**Re: Alterations to Cote Royd House, Former Stable Building,  
7 Halifax Road, Edgerton, Huddersfield, HD3 3AN**

We were instructed to report upon the structural implications of the proposed alterations to the above listed property. I visited the property on the 4<sup>th</sup> March 2015, in your company to consider the proposals and the effects of the removal of the existing walls would have on the property, bearing in mind that the property has a listed status.

Rev	Description	Date	By	App'd
	Proposed Residential Development Cote Royd House, 7 Hallifax Road, Huddersfield HD3 3AN	14-033	20/01/15	
	Second Floor Plan as Proposed	Scale @ A3 1:100	MO	
	Client John Roberts	Drawing no AL0013	Rev	-

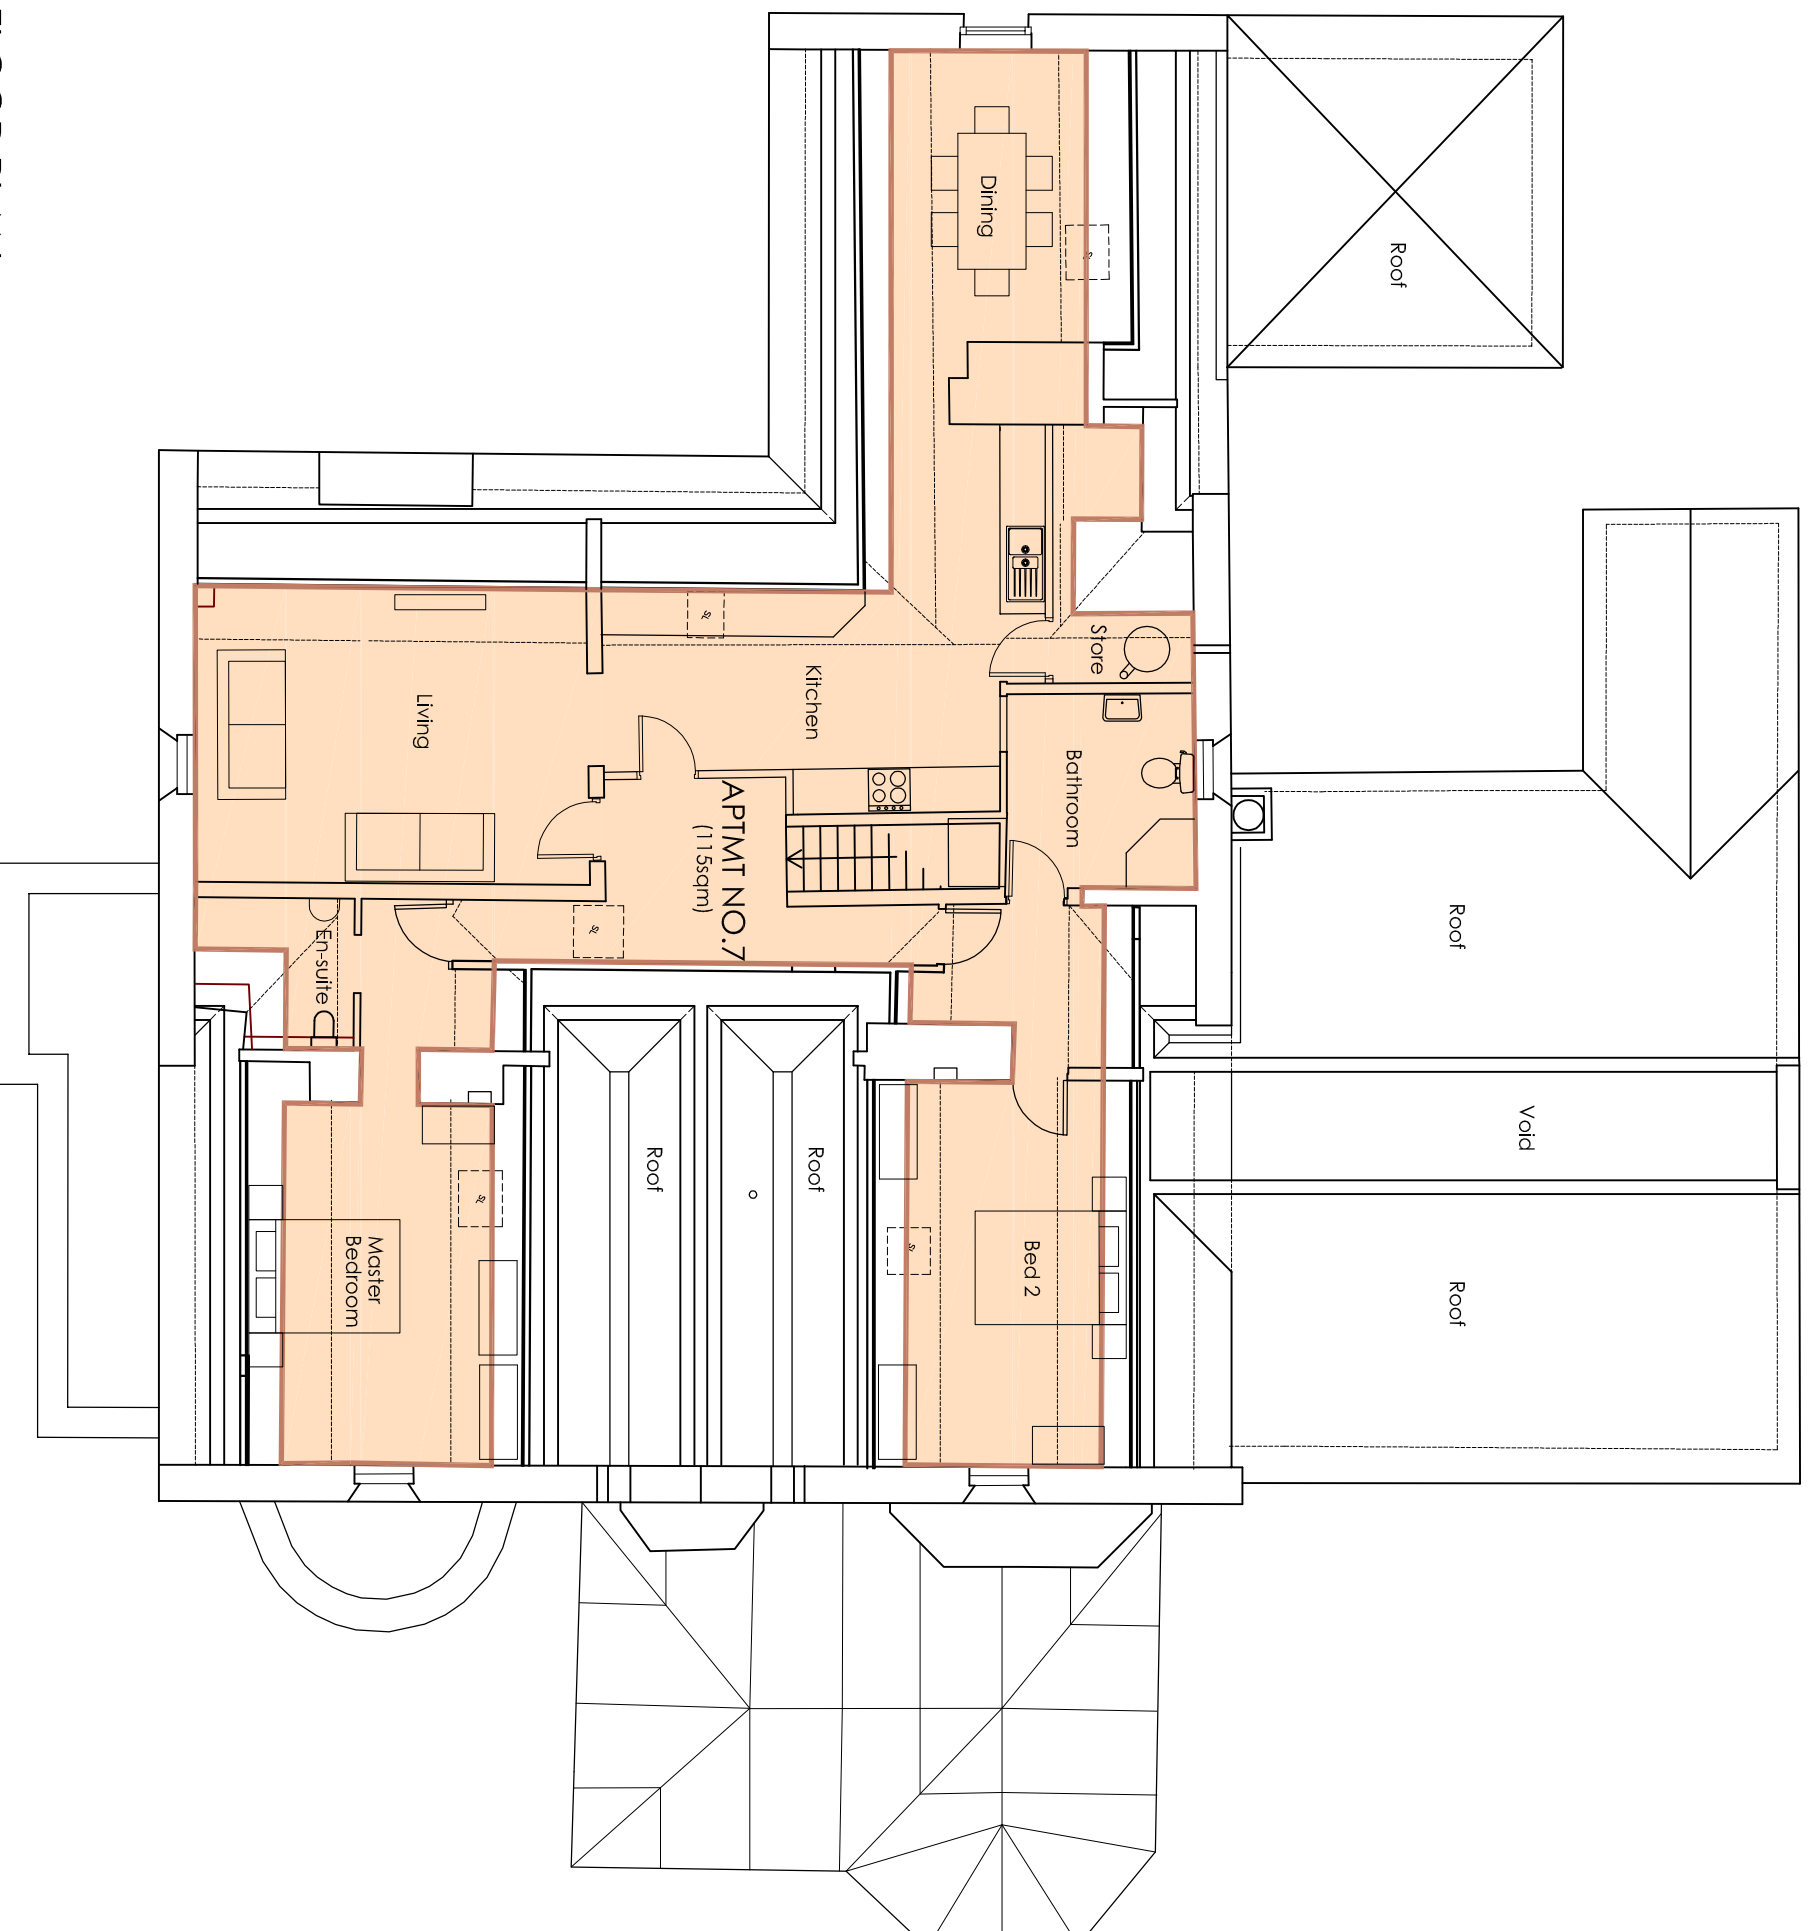
The existing en-suite is to be removed and these are timber stud partitions which do not form part to the original fabric of the building. There are no structural implications.

The glass partition at the head of the stairs is an internal feature that is a later addition to the property and it has no structural implications.

Rev	Description	Date	By	App'd
Project	Proposed Residential Development Cote Royd House, 7 Hallifax Road, Huddersfield HD3 3AN	14-033	20/01/15	
Drawings Title	Cellar Plan - Demolitions as Proposed	Scale @ A3 1:100	Drawn by MO	App'd by -
Client	John Roberts	Drawing no AL0005		Rev -

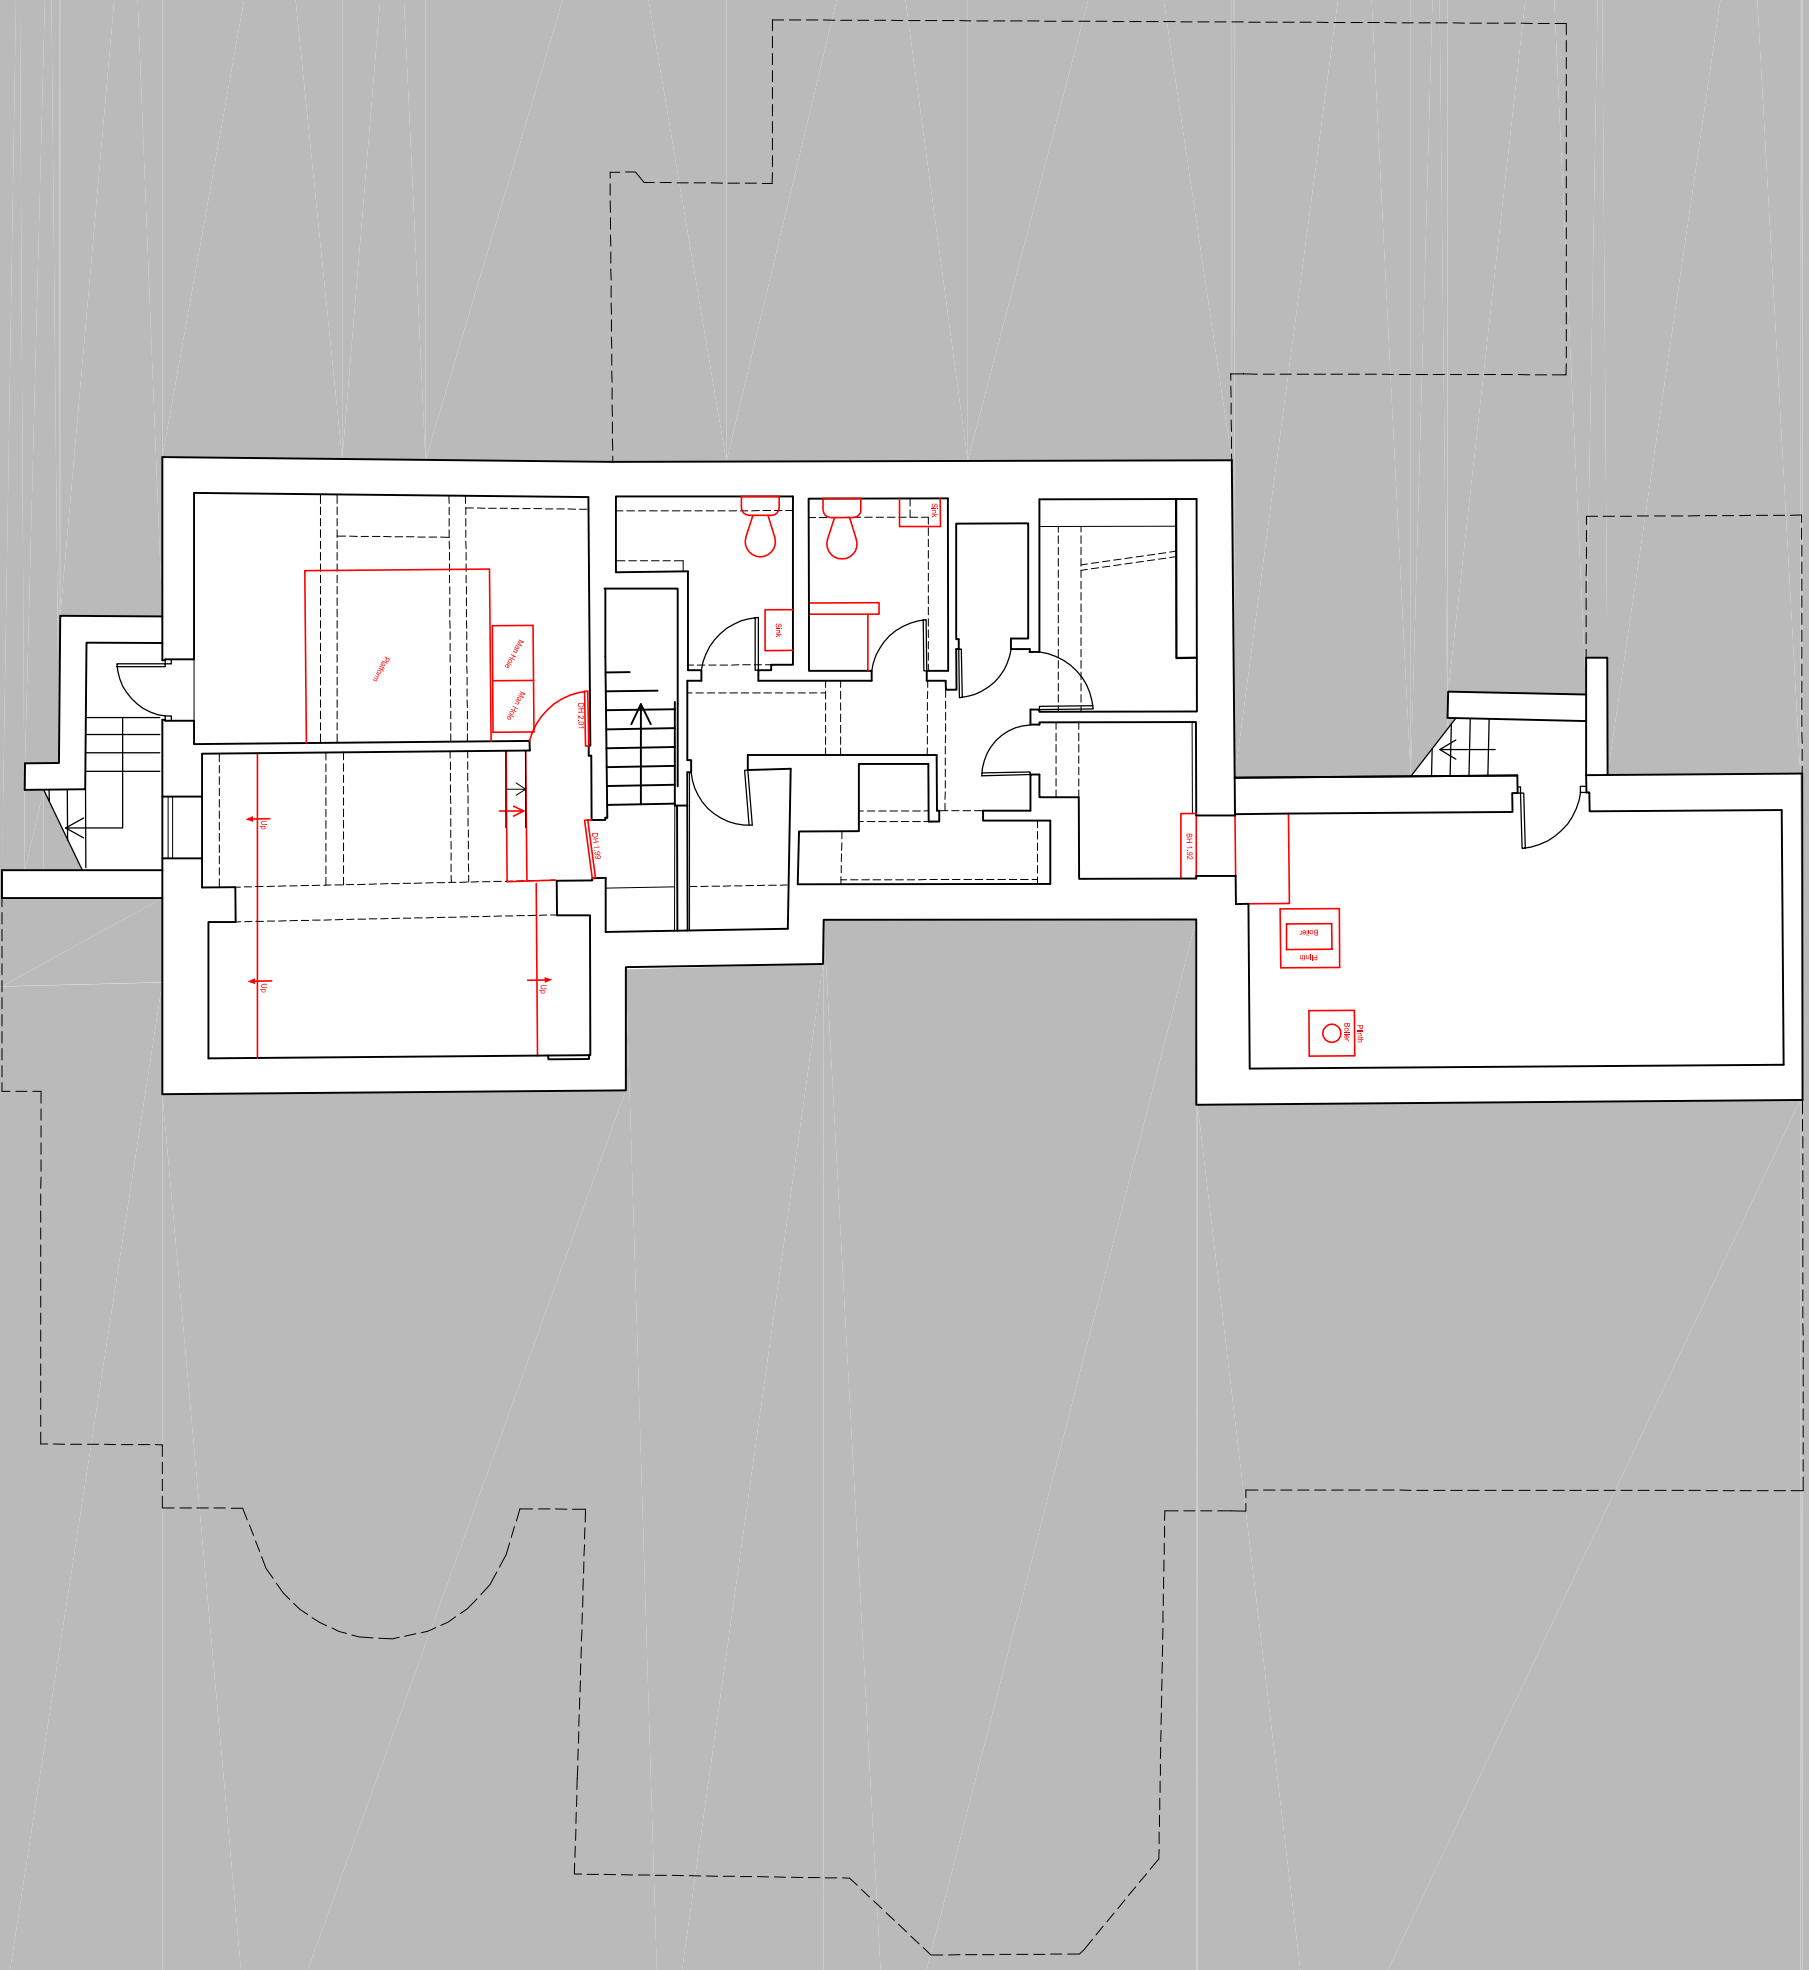
A new narrow door opening is required to link the vaulted cellar to the main cellar. Some investigation is required in this area as it is at the location of a chimney breast. An inspection of the main chimney stack shows that this is offset from the chimney breast and appears to rest directly above the vaulted ceiling to the cellar. There is possibly a transition beam above the cellar taking the load of the chimney onto the front and rear walls of the cellar. Again a Structural Engineer should investigate this area during the course of the work, however, at this stage we envisage the inclusion of further masonry walls directly below the upper chimney stack which should be seated on to a new concrete foundation within the vaulted cellar.

Rev	Description	Date	By	App'd
	Project			
	Proposed Residential Development	14-033	20/01/15	
	Project no			
	Cole Royd House, 7 Halifax Road, Huddersfield HD3 3AN	Scale @ A3	Drawn by	App'd by
	Drawing title	1:100	MO	-
	First Floor Plan as Existing	Drawing no		Rev
	Client	EX0012		
	John Roberts

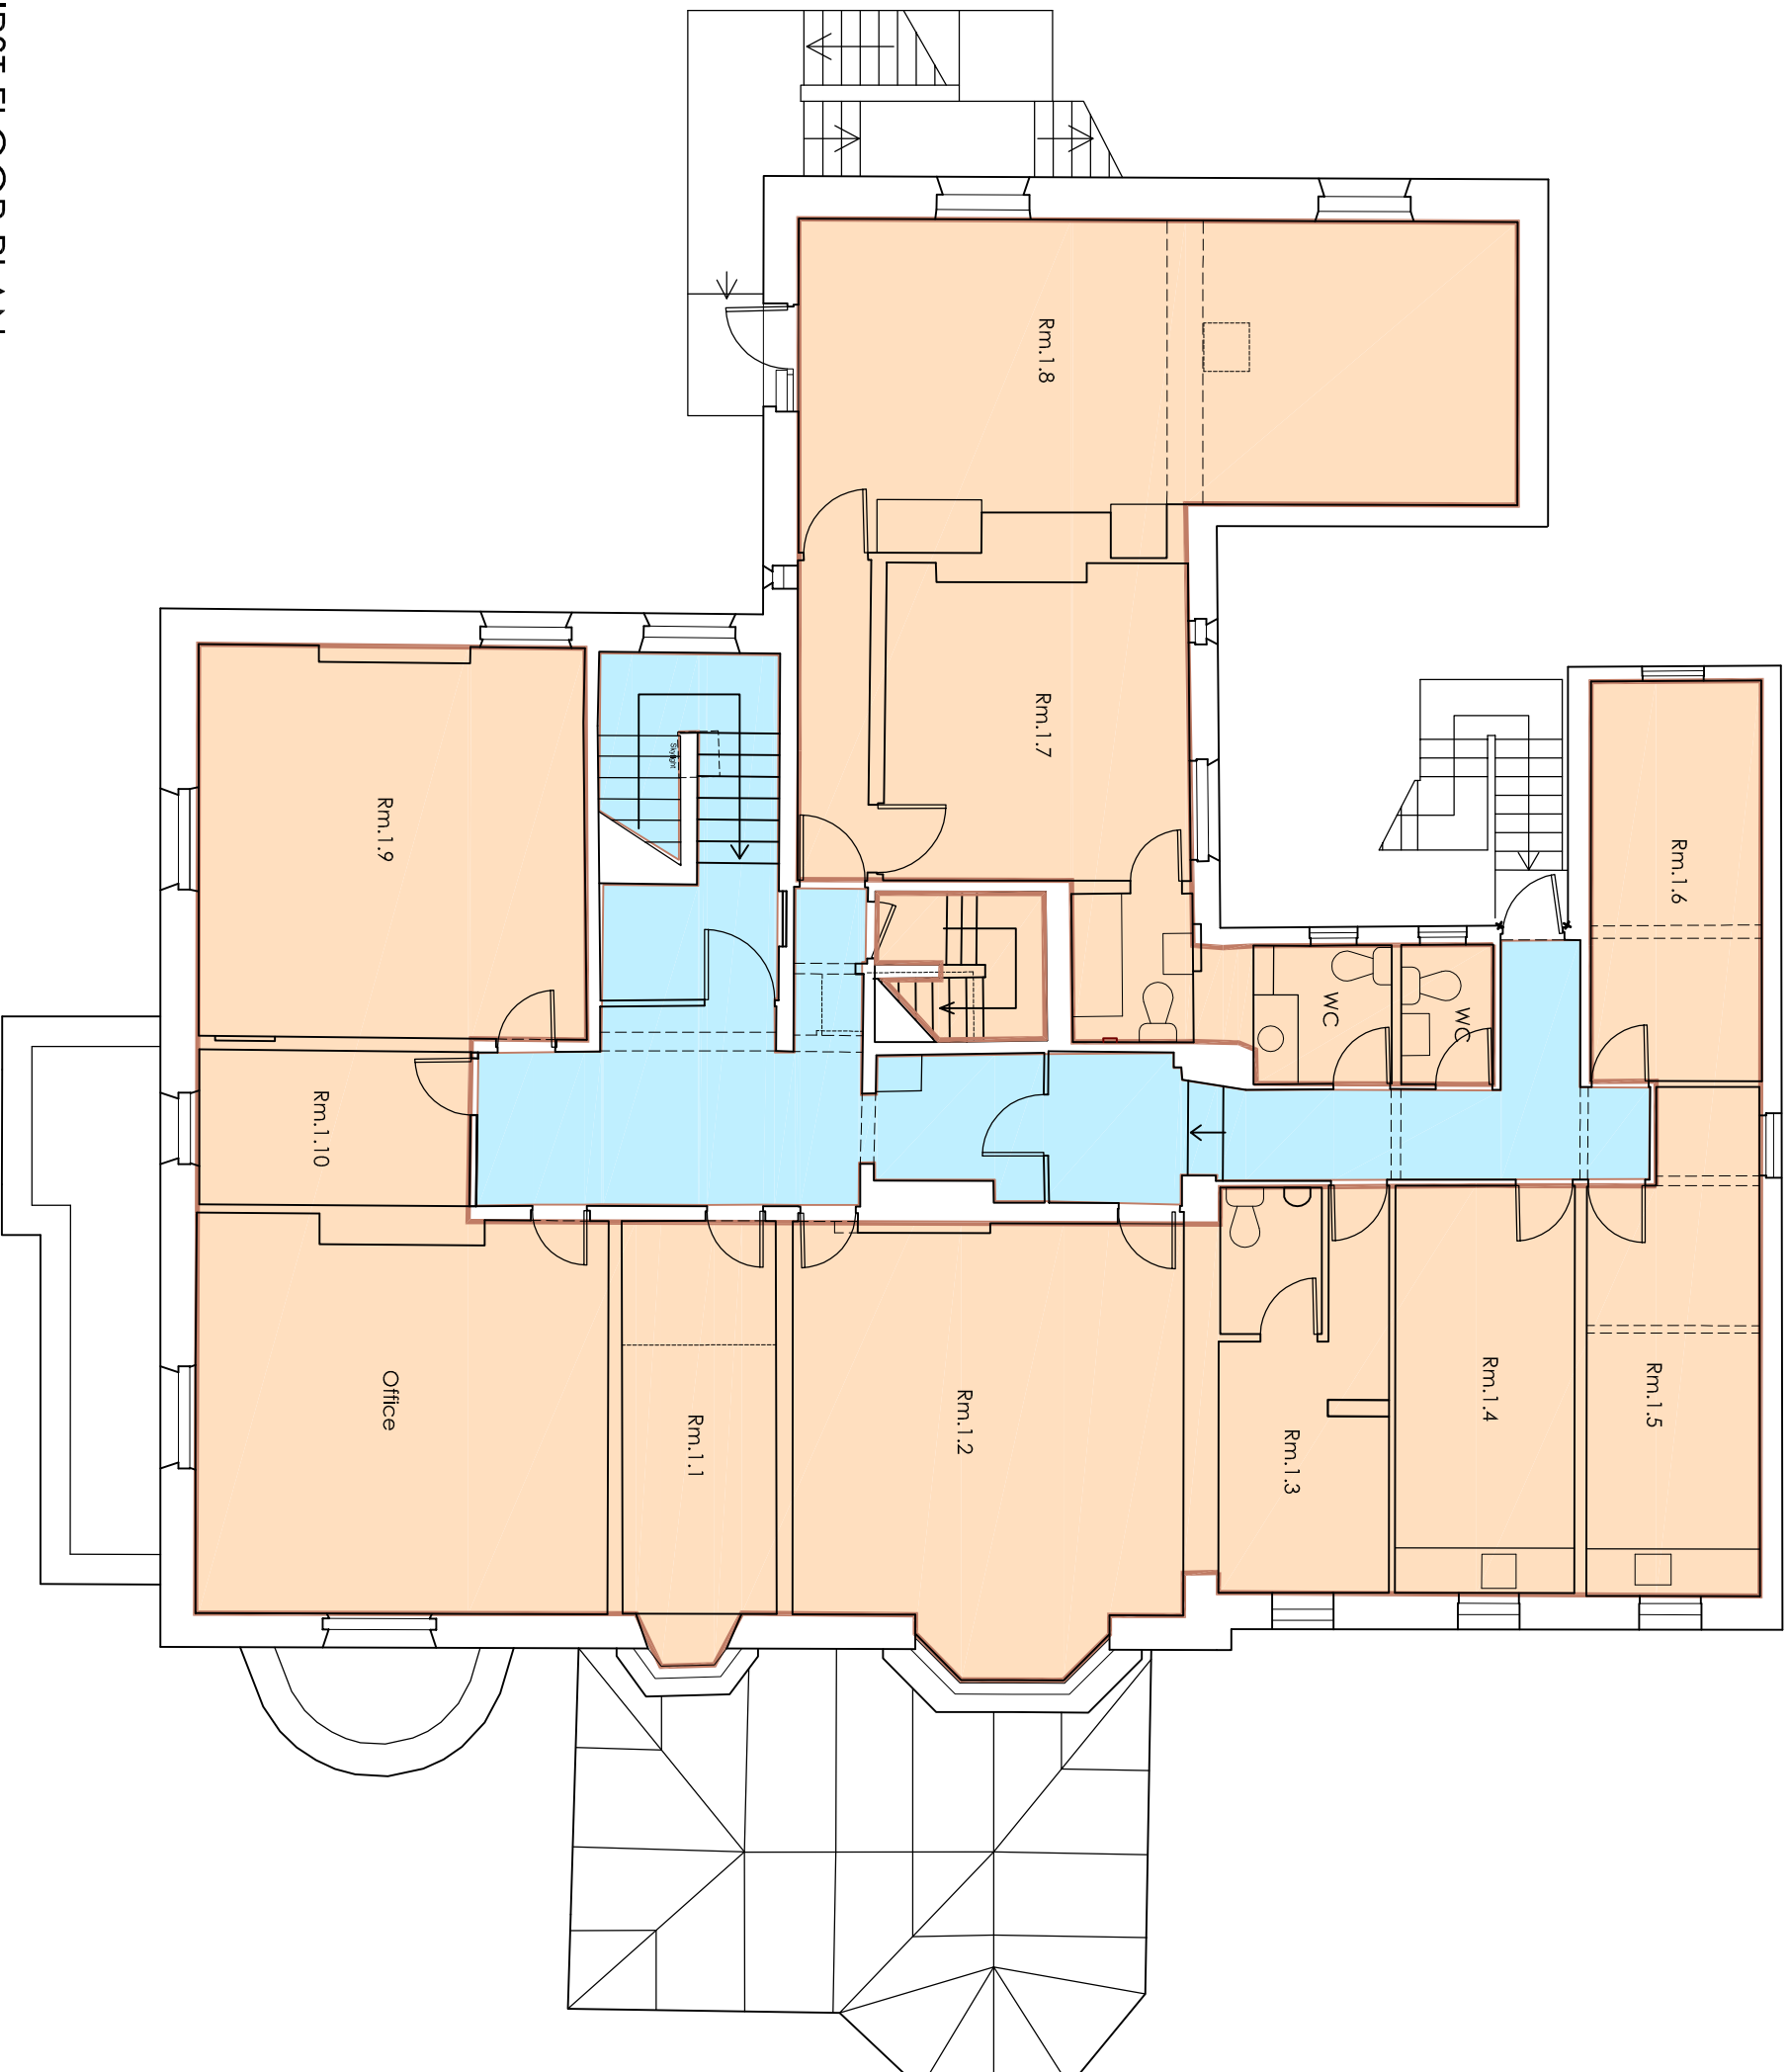
A new opening is required between the left hand room and the central room. The new opening is at the location of a previous opening between the two rooms and is returning the structure back to its original. There are no structural implications with regards to this new opening.

The corridor walls are to be removed in the 1970's extension. These are all timber stud partitions and are non-load bearing. In addition to this the masonry walls which run front to rear are to be removed and these again are non-load bearing walls and can be seen within the roof space to exit through the ceiling boards. This more clearly described on Sketch SK1 appended.
